13 May 2020

File No: 2020/197303

**WestConnex M4-M5 Link (SSI 7485) Modification 2 Design Amendment – Stage 3B  
Rozelle Interchange**

Figure 1-1 Revised design

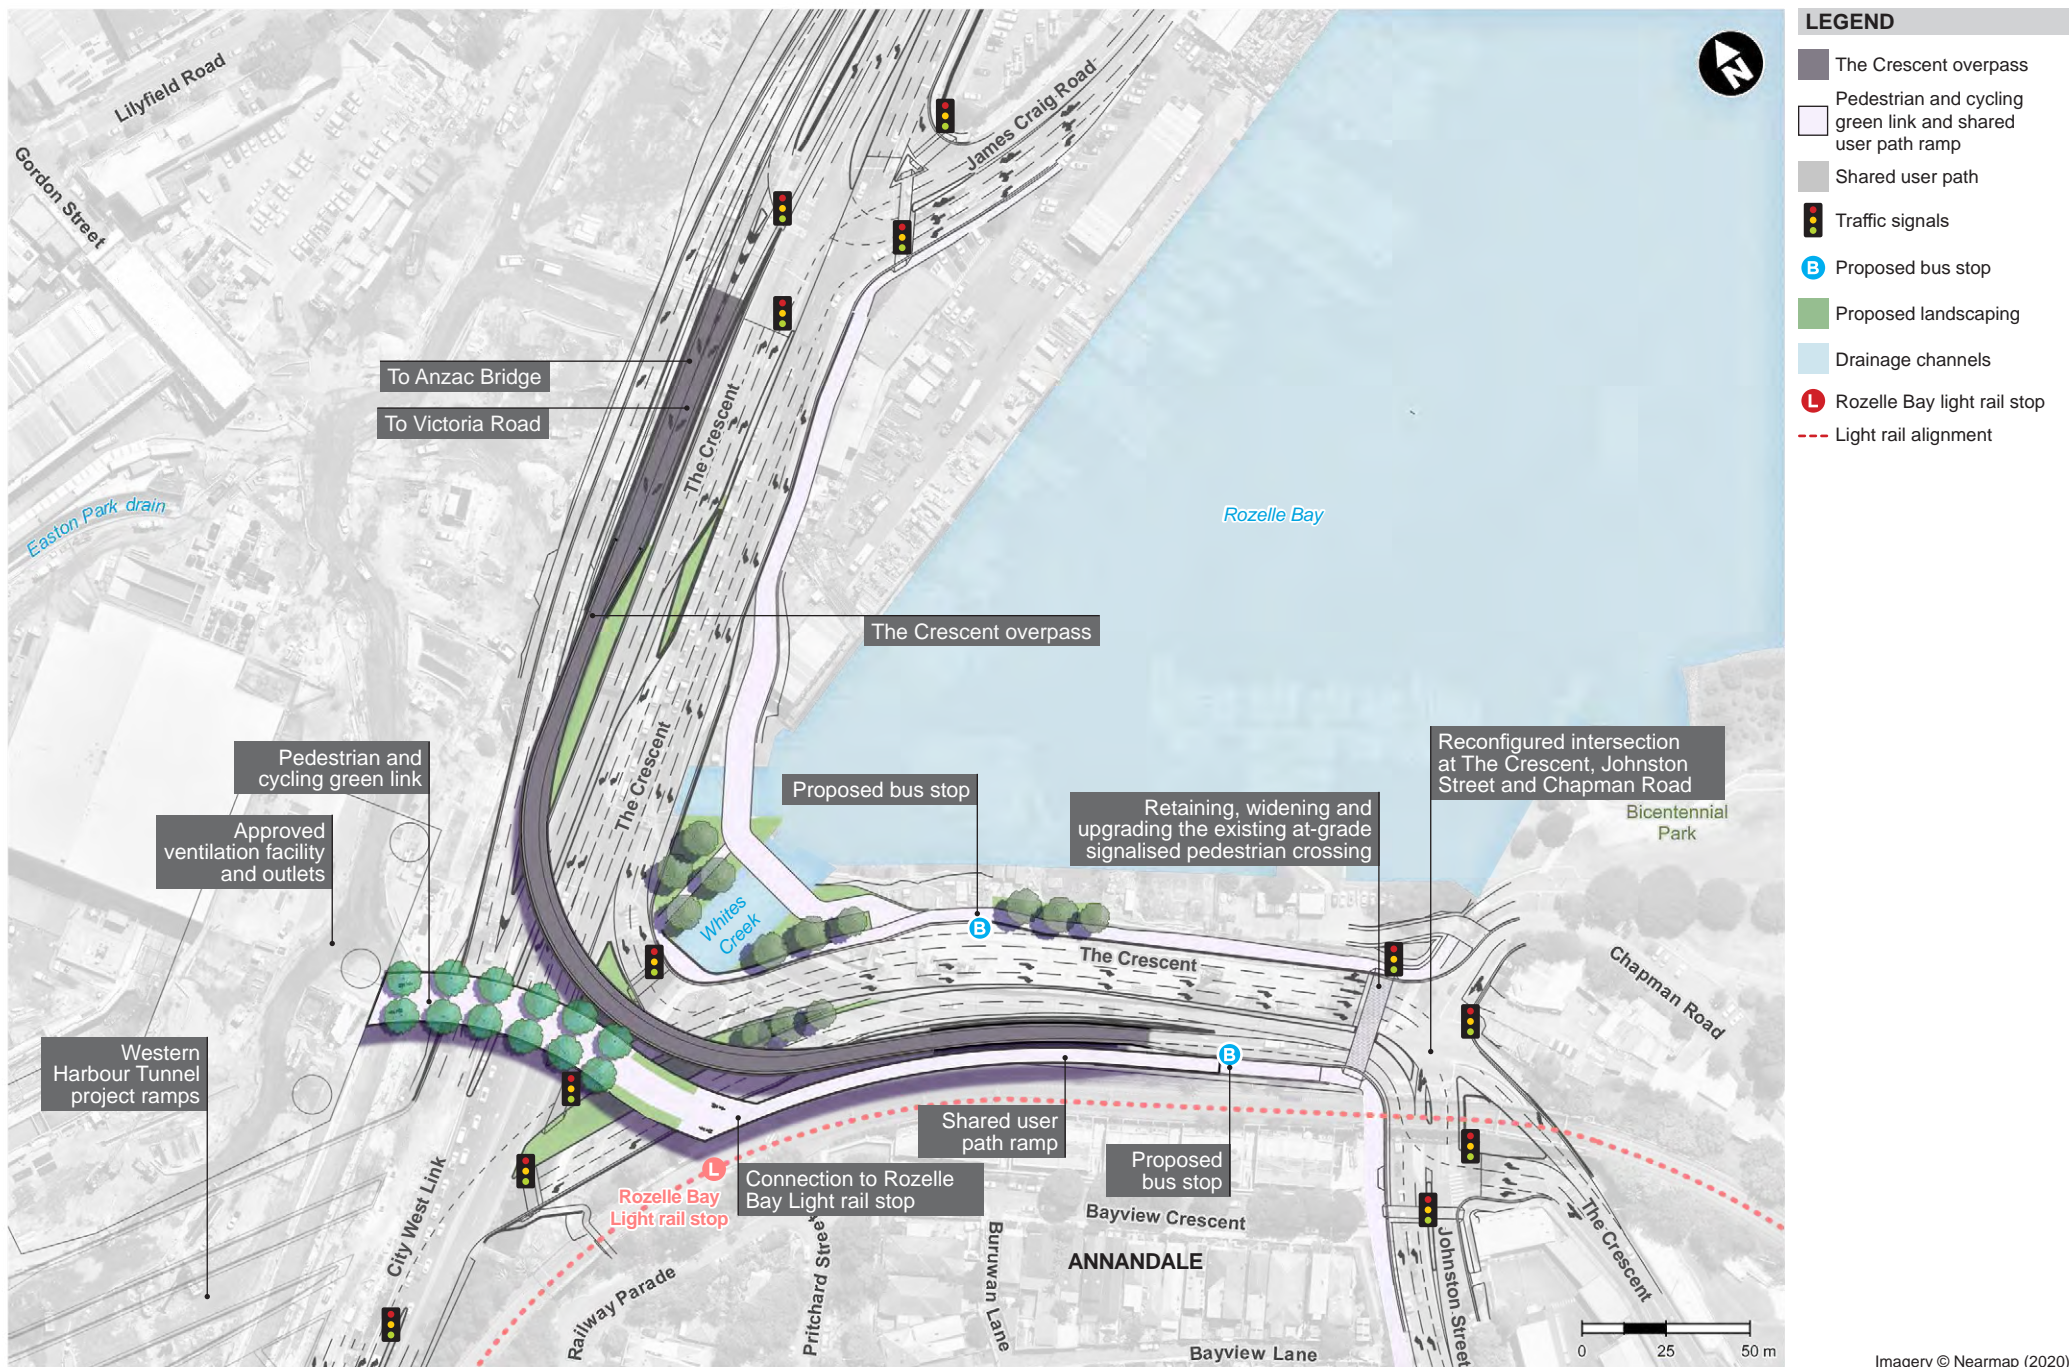
- Lowering the height of the proposed overpass by around two metres at its apex so it is a similar height to the green link
- Changing the design of the southern section of the green link to improve its amenity and interface with the Rozelle Bay light rail stop

Pedestrians moving between the new parkland west of the City West Link and Federal Park will have to walk along a path which, in part, is sandwiched between the shear retaining wall of the light rail and the free right turn overpass viaduct carrying fast moving vehicles, with no views to the bay and poor surveillance. In addition, towards the crest of the Green Link, the vehicle overpass is at a similar grade but at a perpendicular direction. This will result in vehicle exhaust directed towards the pedestrians and cyclists on the green link. This is in contrast to the potential for pedestrians to have a direct link between the parkland areas beside the bay.

- Remove the vehicle overpass, as proposed in Modification 2, and revert back to the EIS design where the Green Link is located along the waterfront. Alternately, the following options should be investigated:

Figure 2-1: Space for pedestrian and cyclists at The Crescent crossing

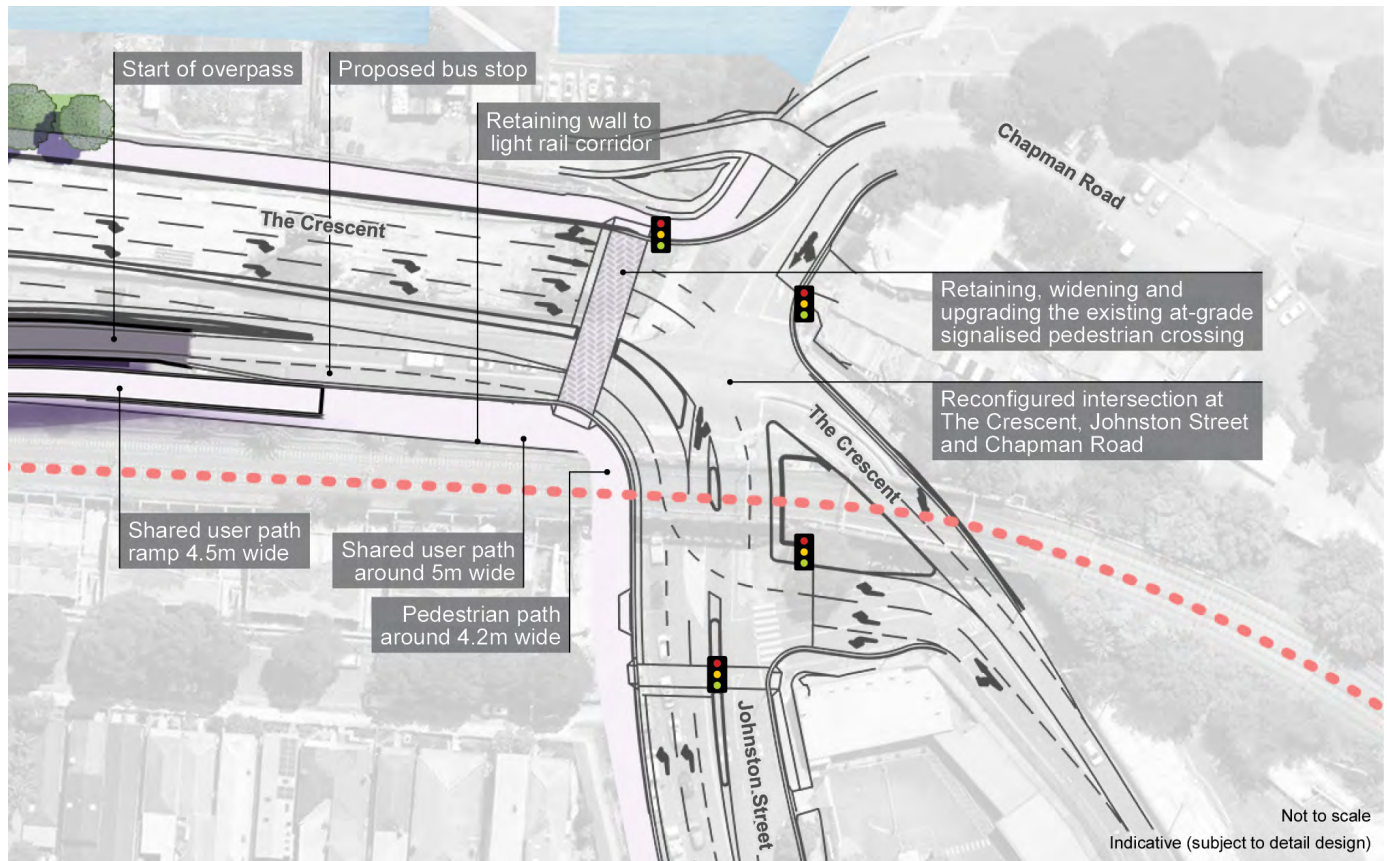
It is noted, however, that there is a significant safety issue at the western end of this crossing due to insufficient pedestrian and cyclist storage area along the west side of The Crescent, north of Johnston Street. This issue is exacerbated by the proximity of the bus stop waiting area and the grade of the ramp from the light rail station towards the intersection. The steep downhill grade will result in many cyclists travelling with considerable speed towards the waiting area at the intersection.

- remove one vehicle lane along The Crescent (southbound) to provide wider footpaths and waiting areas along the west side of The Crescent, north of Johnston Street

- provide better median treatments (such as Elsholz redirective kerbs) along The Crescent
  - acquire properties on the west side of The Crescent to provide space to widen footpaths
